**WELWYN HATFIELD BOROUGH COUNCIL
EXECUTIVE DIRECTOR - PLANNING, PUBLIC PROTECTION AND GOVERNANCE**

DELEGATED APPLICATION

Application No: 6/2017/2962/FULL
Location: Rhodes Wood Hospital, Shepherds Way, Brookmans Park, Hatfield, AL9 6NN
Proposal: Erection of a single storey detached therapy building
Officer: Mr David Elmore

6/2017/2962/FULL

Title
Proposed Elevations & Section

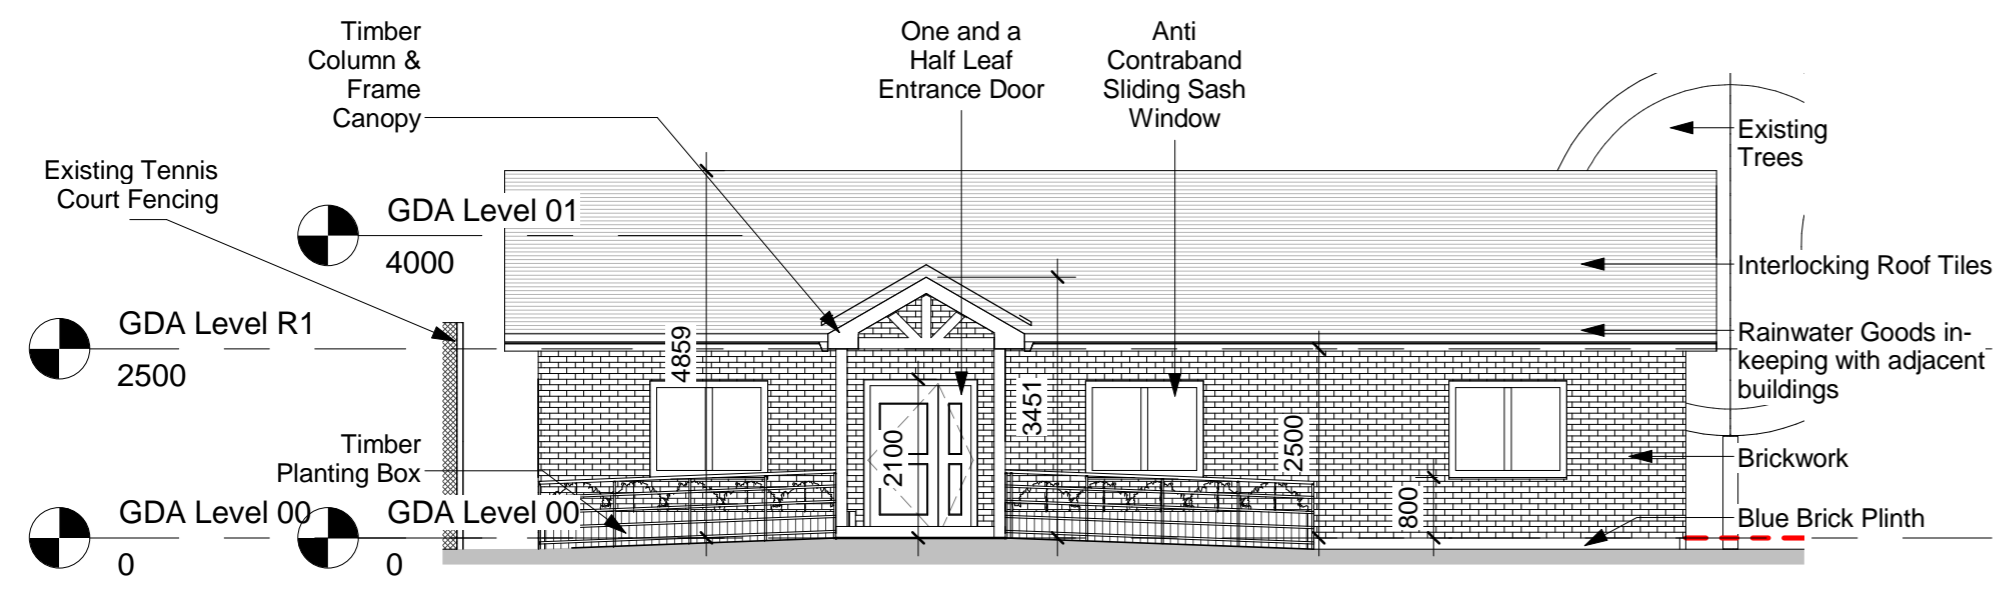
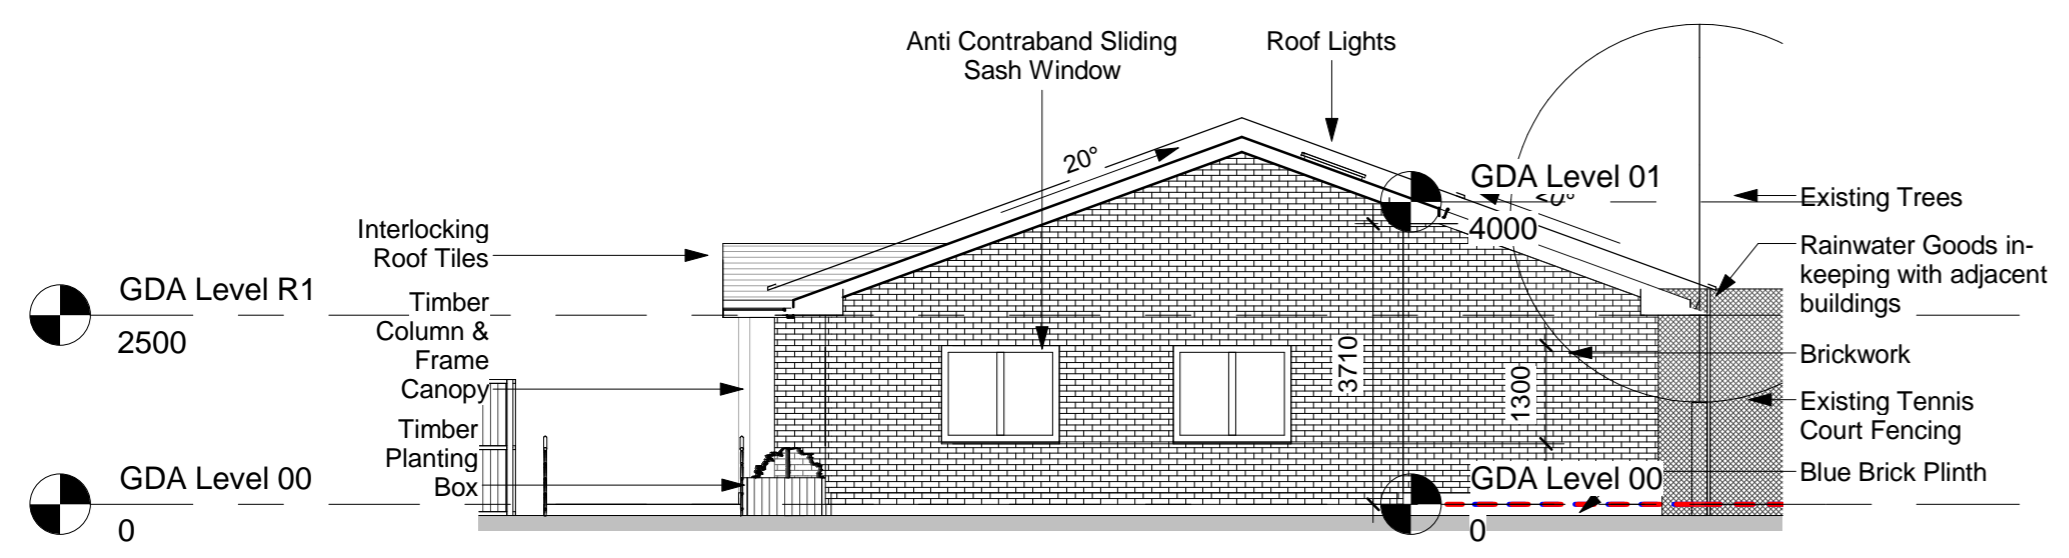
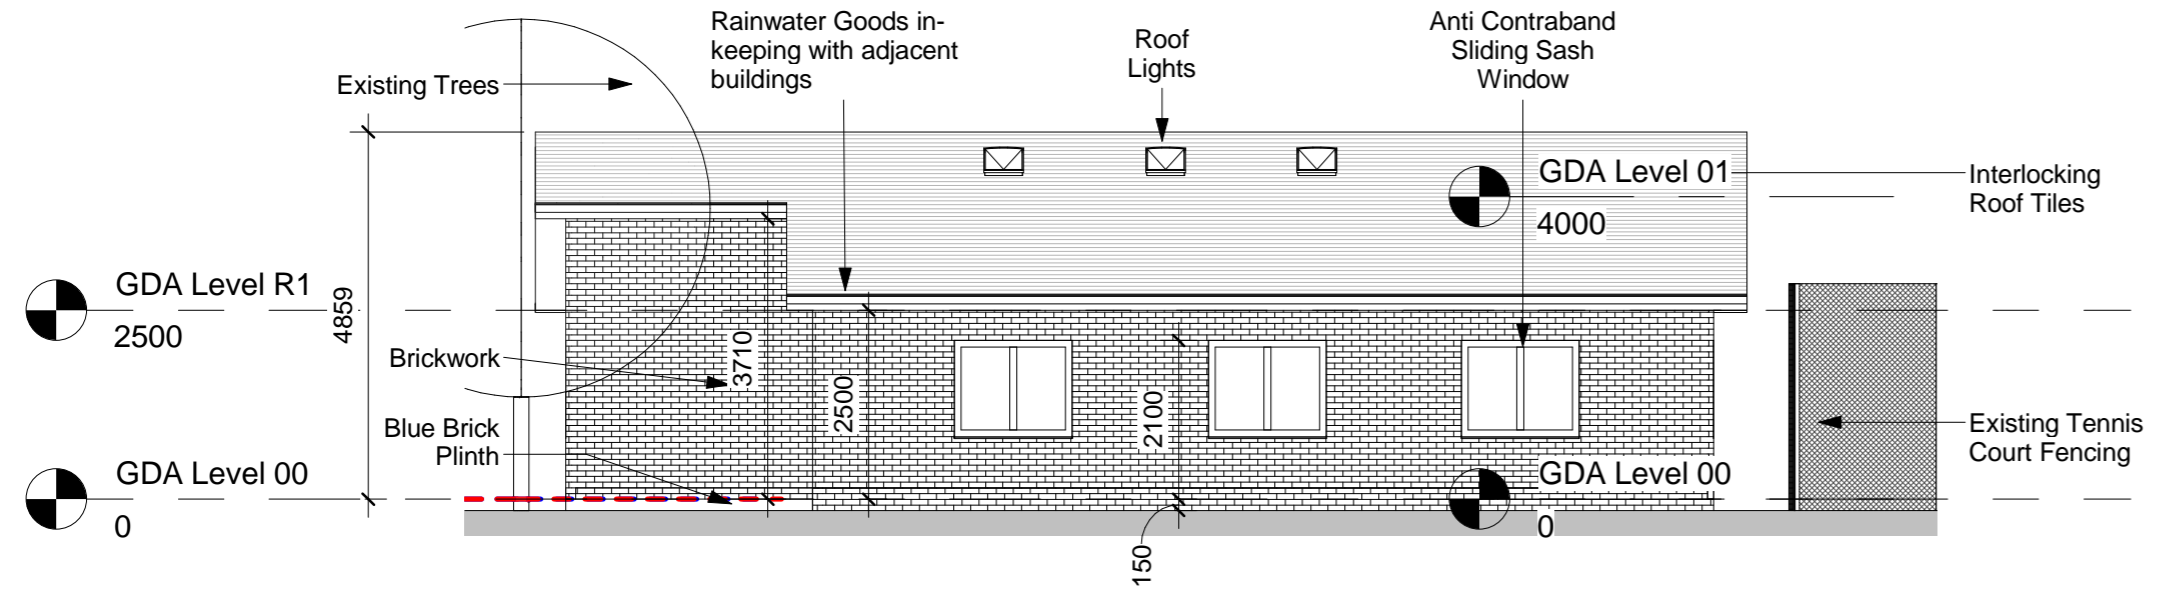
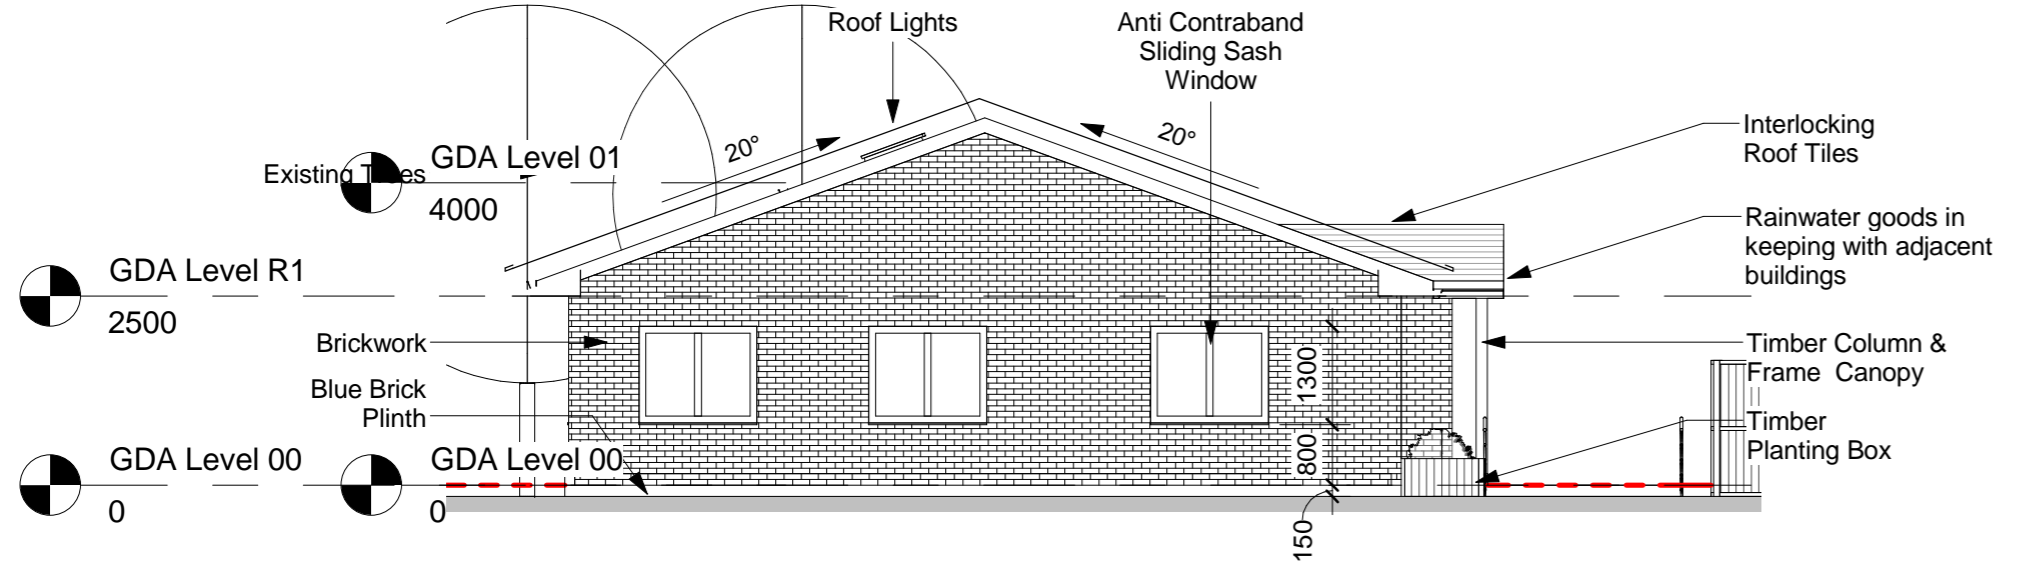
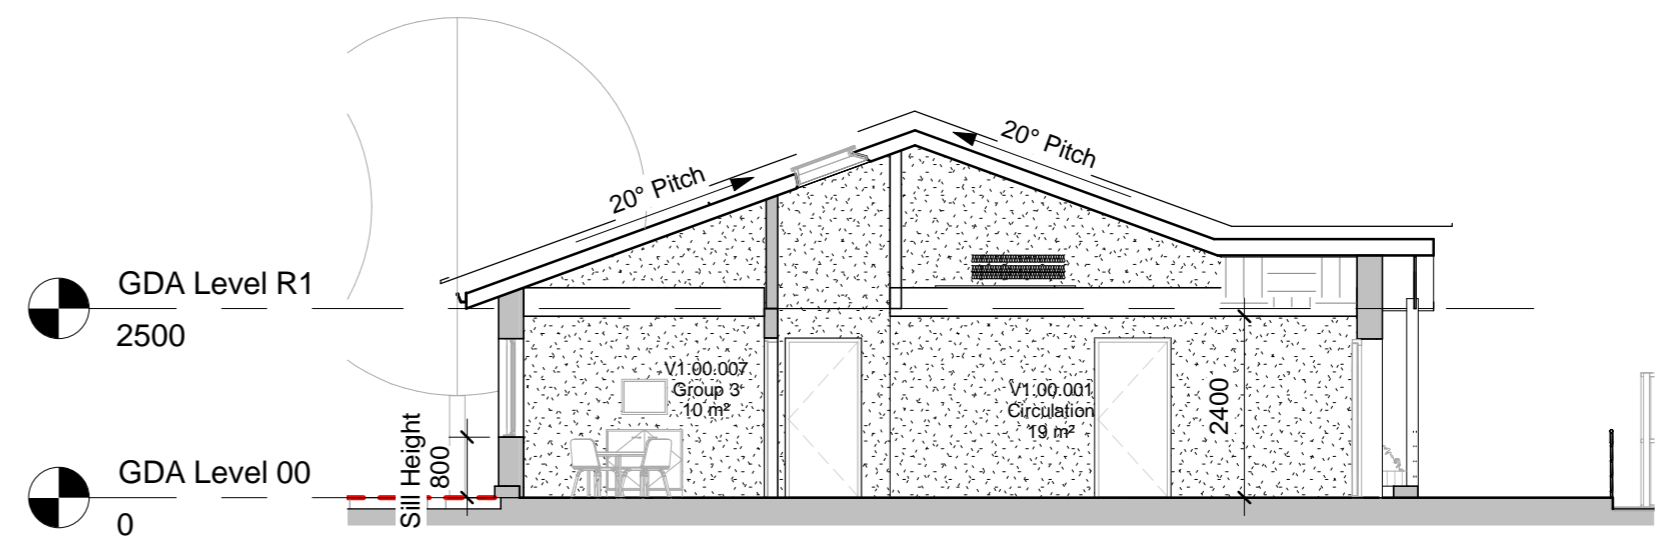
The Council's Historic Building Advisor has been consulted for this application. Concerns were initially expressed regarding the style and materiality of the proposed therapy building. Following negotiations with the case officer, the materials of the proposed building have now been amended to brick to match those of the existing adjacent brick extension to the main Mymwood House.

The proposed therapy building would be single storey with a dual pitched roof. Its footprint would measure approximately 154sqm with a total height of approximately 5.15m. The external materials are intended to match exactly those used on the adjacent single storey extensions to Mymwood House (Ref: S6/2007/1704/MA & S6/2007/1711/LB). This incorporates the use of a yellow/buff brick facing and slate roof tiles.

The Council's Historic Building Advisor was re-consulted and considers that the amended materiality of the proposed therapy building would be sympathetic to the listed building and presents no concerns. Overall, the Council's Historic Building Advisor considers that whilst the proposed building would cause harm to the significance of the respective listed building due to the change in setting, the level of harm was considered minimal and toward the lower end of the scale of less than substantial. Paragraph 134 of the NPPF states that less than substantial harm must be weighed against the public benefits of the proposal.
